From
The Member Secretary
Chennai Metropolitan
Development Authority,
No.1, Gandhi Irwin Road,
Egmore, Chennai-600008.

Letter No. B1/12187/05

Dated: 8-8-05

Sub: CMDA - Area Plans Unit - Planning Permission - Proposed
Construction of 5th Floor + 3 floors residential
building with 6 dwellings at DOM No: F-81,
Plot No: 169, IInd Street, Anna Nagar East, S.No: 48,
TS No: 48, Block No: 2, Periyar Cultural Village, Chennai-8
called for - 1st.

SECTION 'A-A'

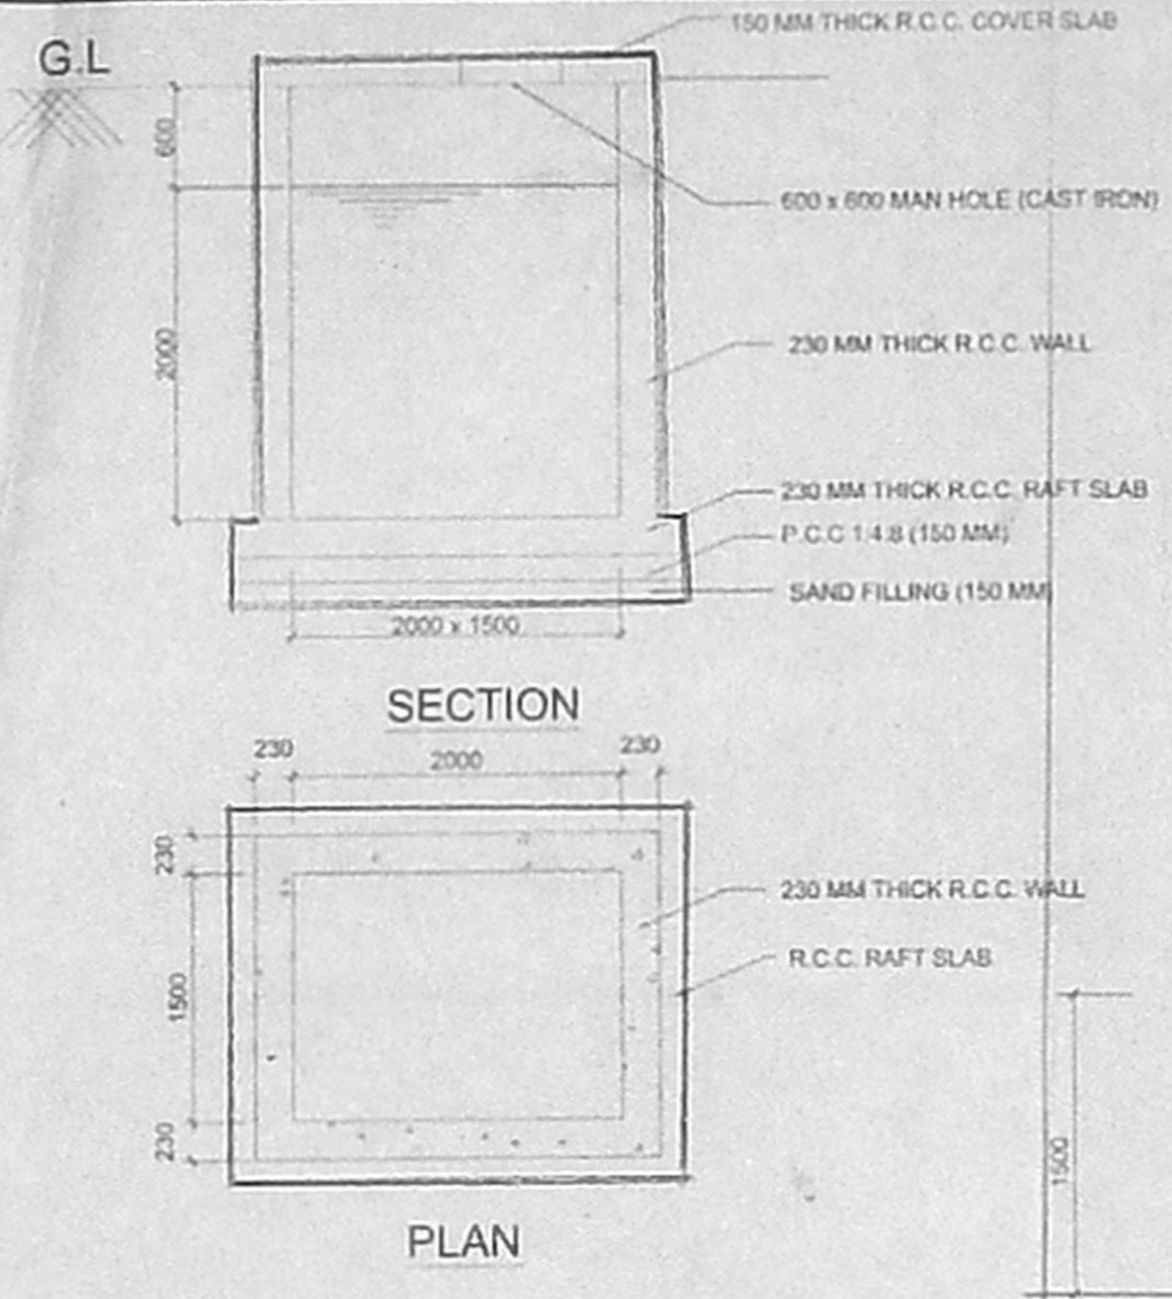
(b) Five copies of revised plans indicating staff height as 2.20m against 2.21m, connecting area statement and Elevation. Jrg.
